**City of Sydney**

Our Ref: R/2009/3/B and 2012/002523

Your Ref: MP 09\_0051 MOD 2

**Section 75W - Centre for Obesity, Diabetes and Cardiovascular Disease  
(CODCD), University of Sydney (MP 09\_0051 MOD 2)**

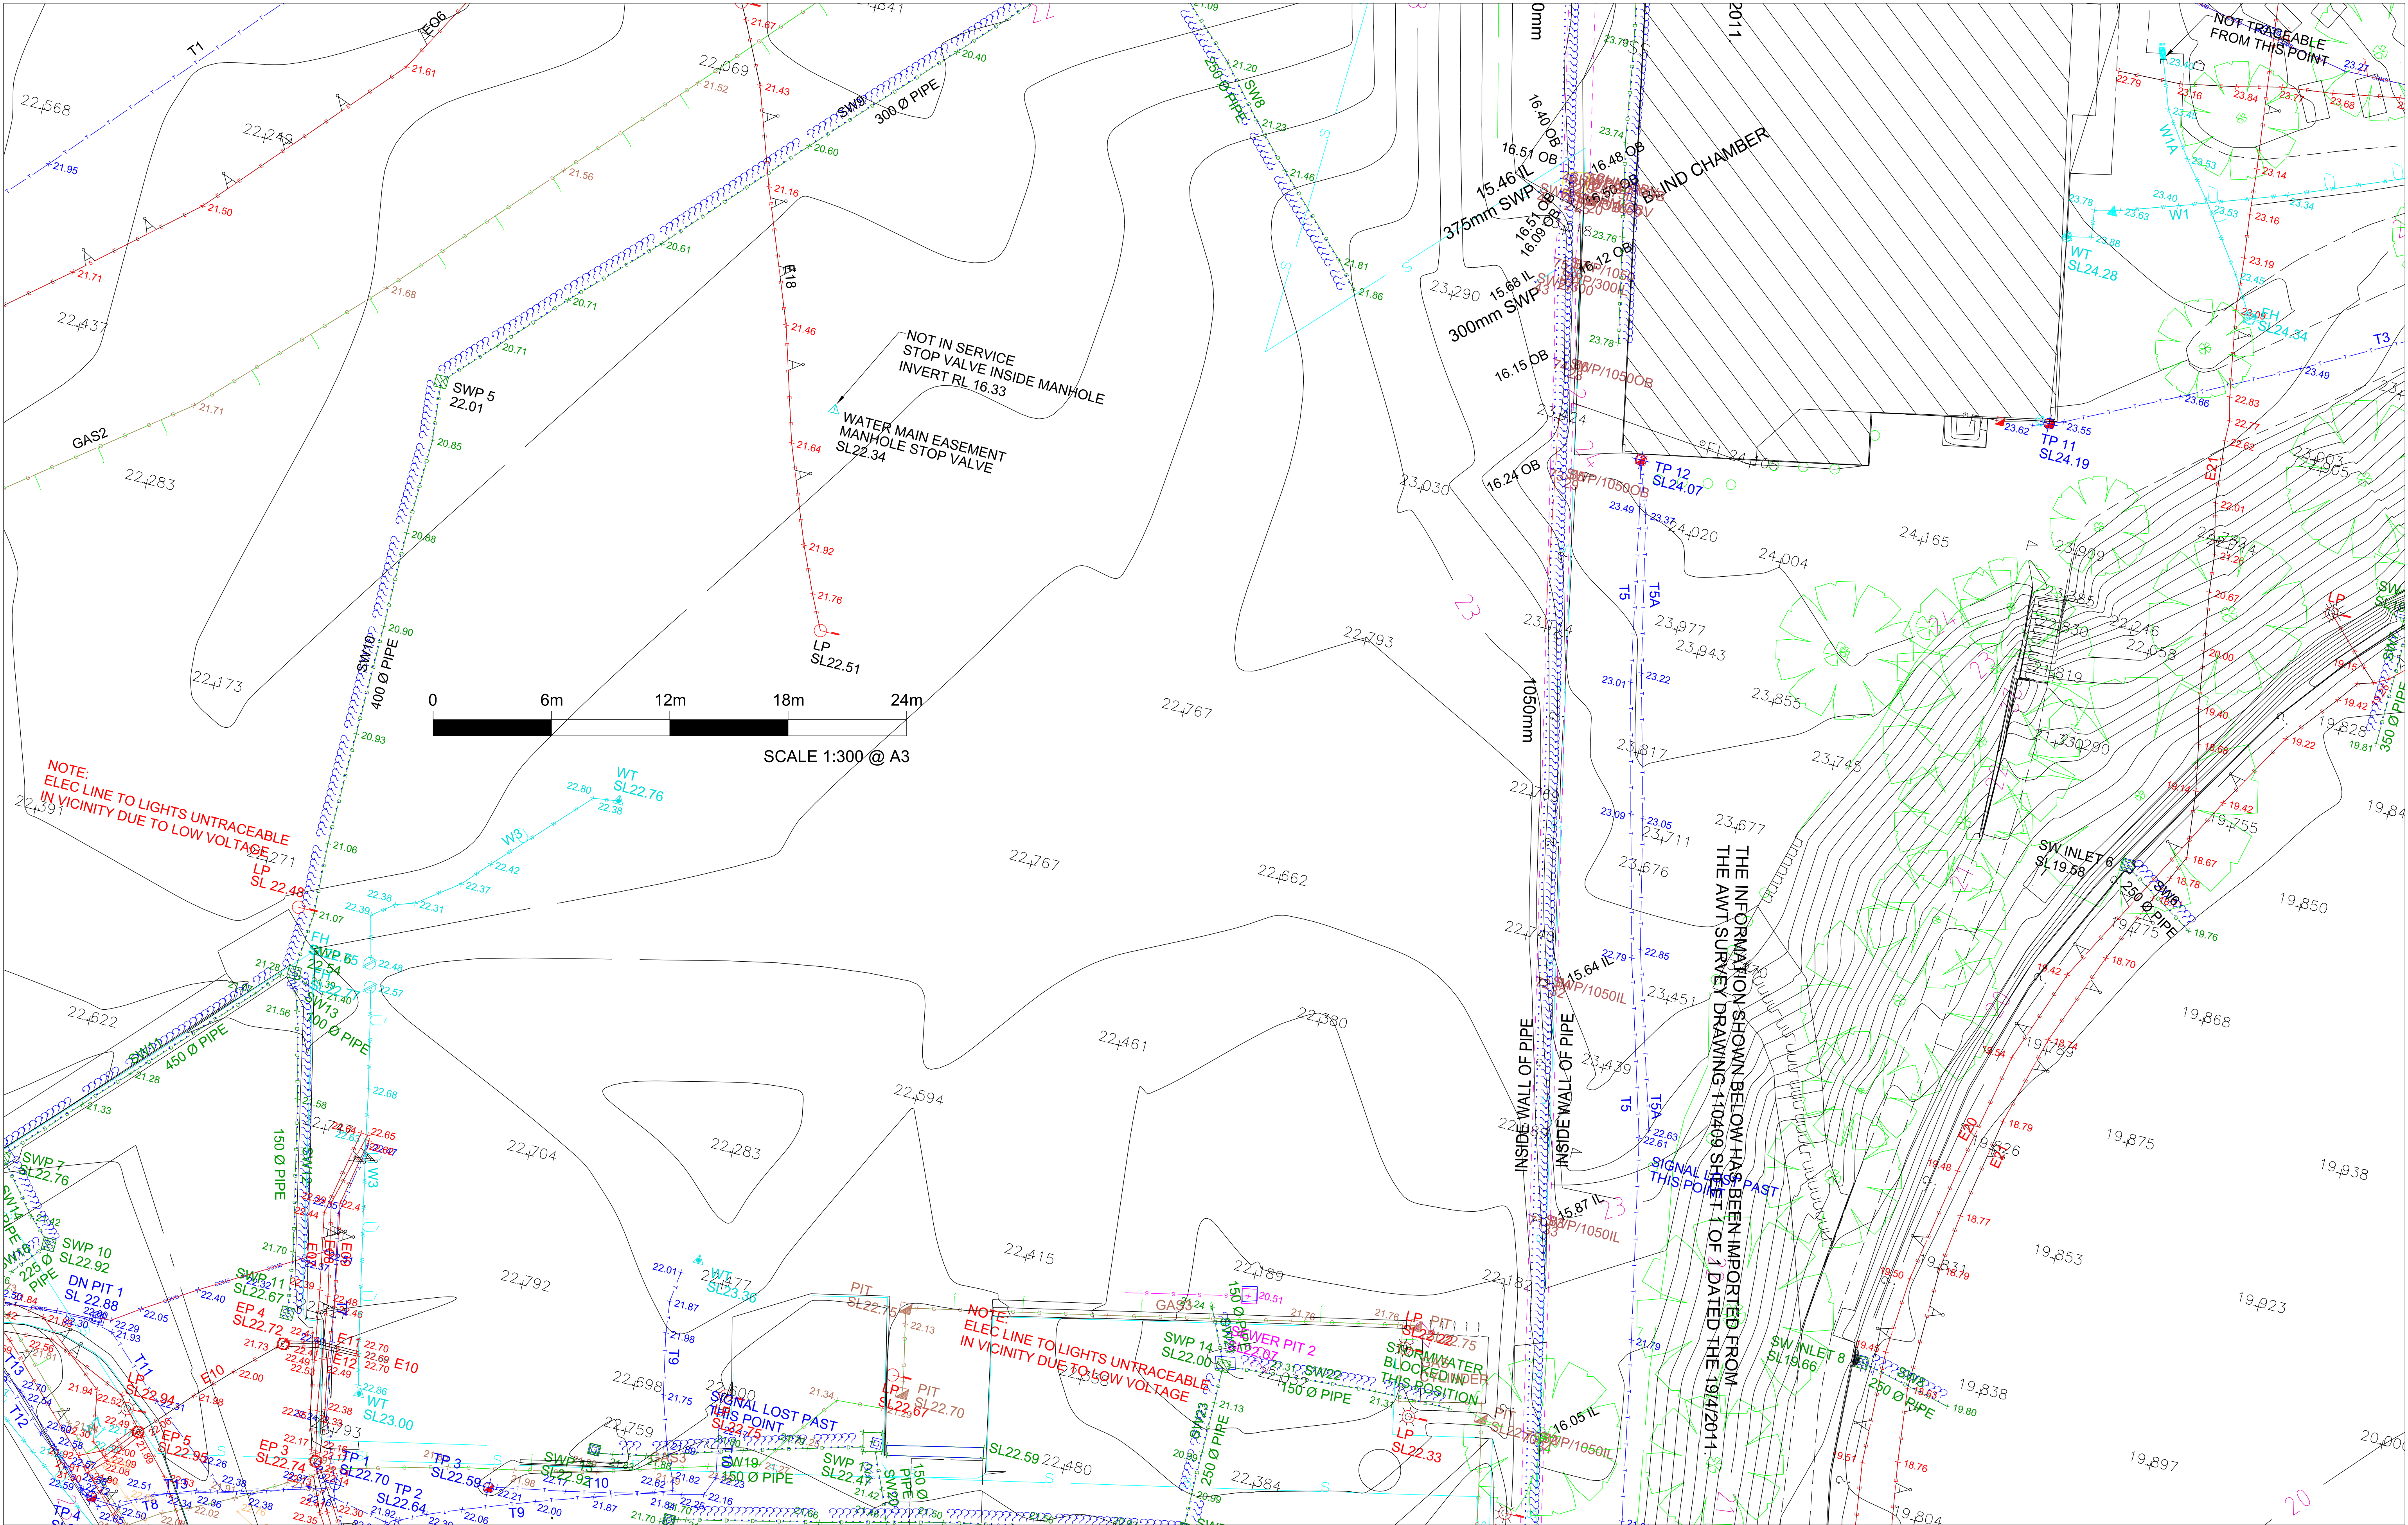
The City is also concerned that the changes are not identified in the EA or supporting reports. The EA contains repeated statements that no changes are proposed to vehicle access arrangements. Changes to the access road are shown on drawings A-DA-012 (Site Vehicular Access) and LA-9400 (Public Domain Plan).

The access road from Parramatta Road has moved and now runs alongside the St John's oval. The approved road is contained mostly within existing internal roads between the Evelyn Williams Building and Buildings BO7 and B10 (see Figure 2).

- it will diminish the landscape buffer between St John's College and the rest of the University campus to the north-east detracting from St John's visual setting;
- it will encroach into the historic grounds of the St John's College impacting on its landscaped setting;
- it is unnecessary as alternative, existing access roads can be used for the most part and further heritage impacts can be avoided; and
- it represents the development's cumulative impacts on the heritage significance of St John's College.

In addition to the change not being addressed in the EA, no details or specialist reports are provided in relation to heritage impacts or tree removal. No detail is provided about how the access road might be integrated into the adjoining landscaped area. There is also no detail on changes to the existing landform and trees to accommodate an 82m ramp at a 1:16 grade.

The proposed relocation of the access road is considered a further encroachment of this development into the curtilage of St John's College and is considered to compromise its heritage significance. It is recommended that the approved access be retained.

**Figure 9:** Visual comparison of improvement on encroachment on alignment of the southern wing of St John's College as originally submitted and as amended compared with that approved.

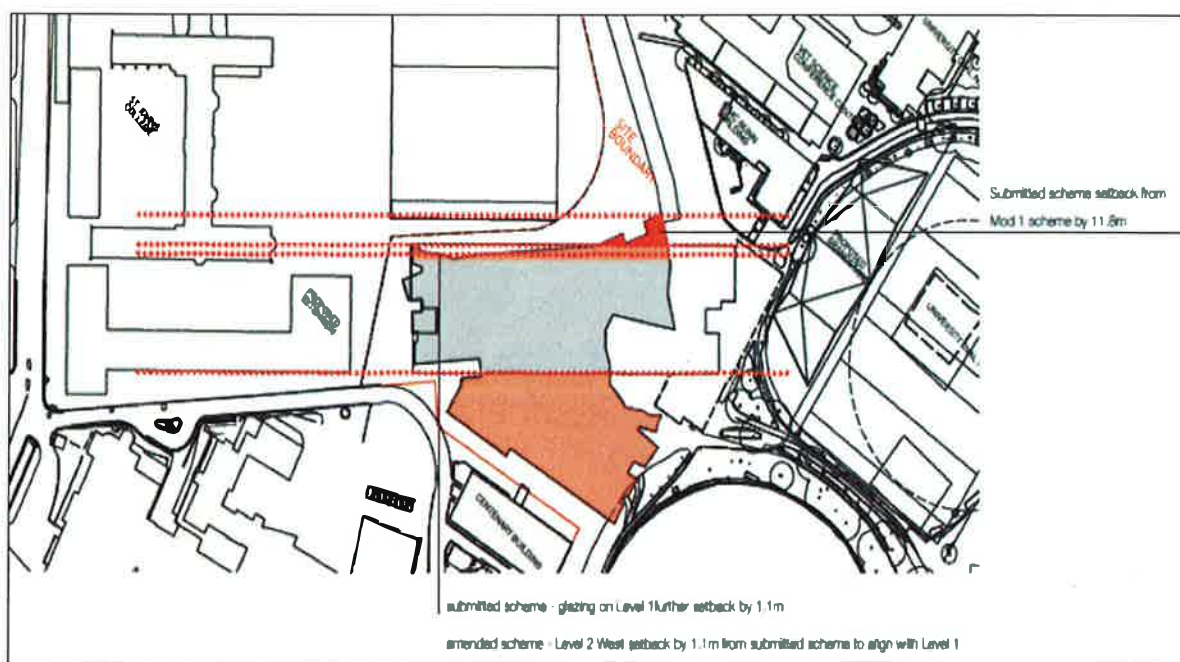
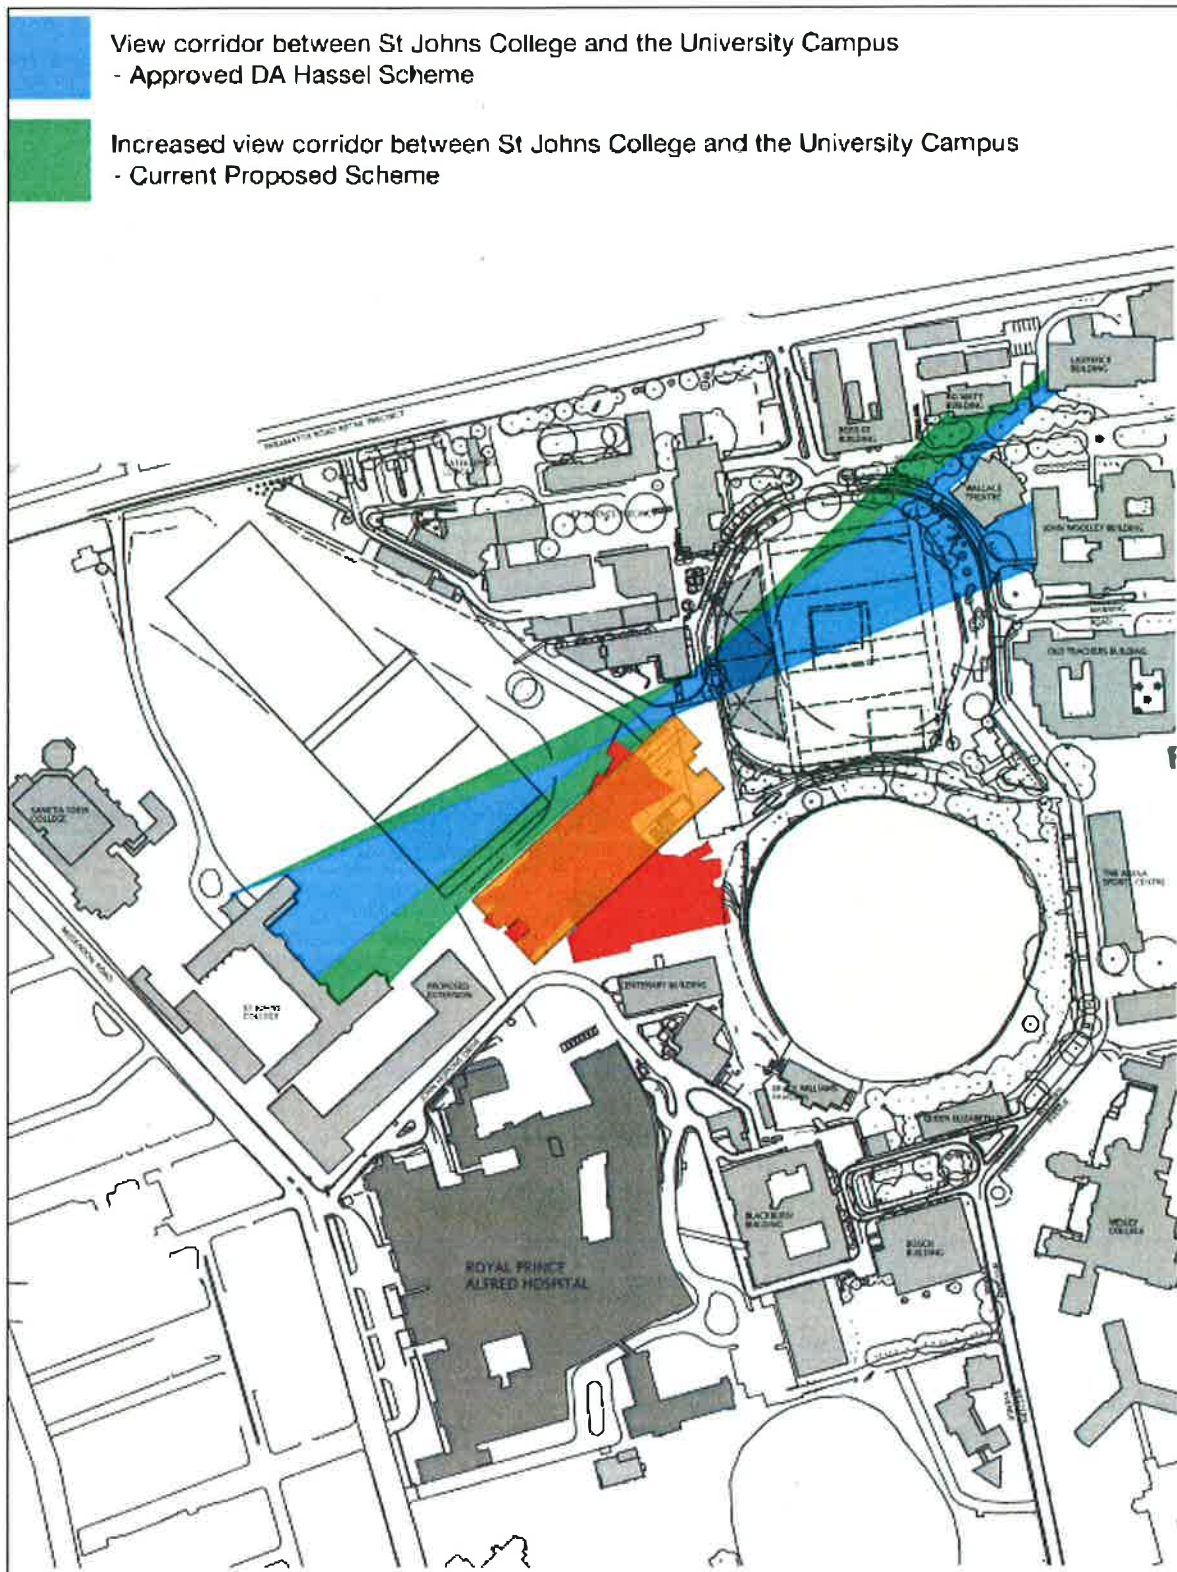
While the revised scheme is simpler, more linear and considered to relate better to its surrounds, contrary to statements in the EA (at 6.4), the northern facade does not follow the alignment of the southern wing of St John's College (see Figure 1).

Although neither the approved nor modified schemes matched this alignment, the City maintains that this is an important view corridor, as identified in the Conservation Management Plan (CMP) for St John's College. Please refer to the City's submission on the original MP, dated 17 March 2010, which includes relevant excerpts from the CMP. The s75W presents an opportunity to reduce the heritage impacts of this development.
